28 Whittier Street Portland

Your drawings seem to show you are removing an existing bearing wall between the kitchen and dining room and replace that bearing wall with a new manufactured beam.

## FIRST FLOOR

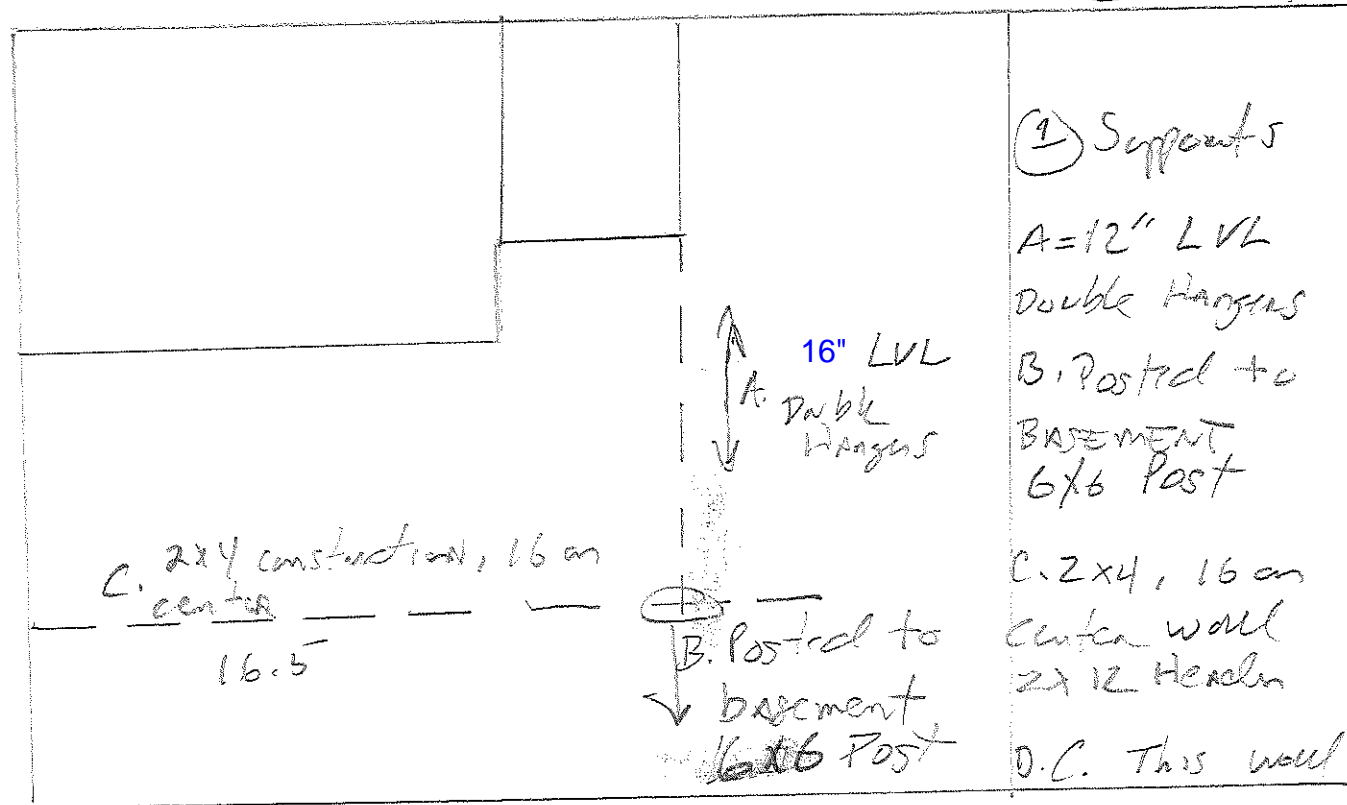
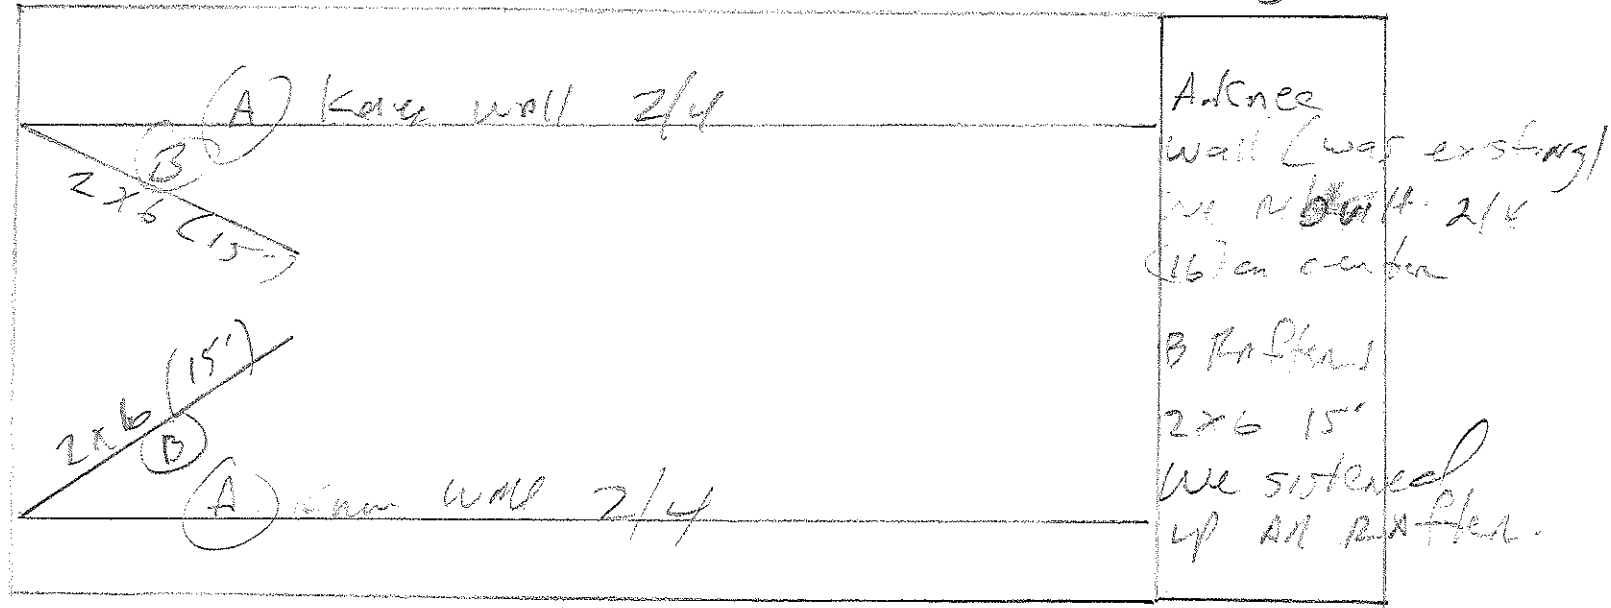
I need to know the design loading (uniform and point loads) and the approved size of the beam. I also need to know the required post sizes at each end of the beam with approved connections as well as how these new point loads will be carried to the foundation or footings in the basement below.

You can provide me with a structural design report (for this specific installation) from the beam manufacturer or have a local structural engineer stamp the approved design.
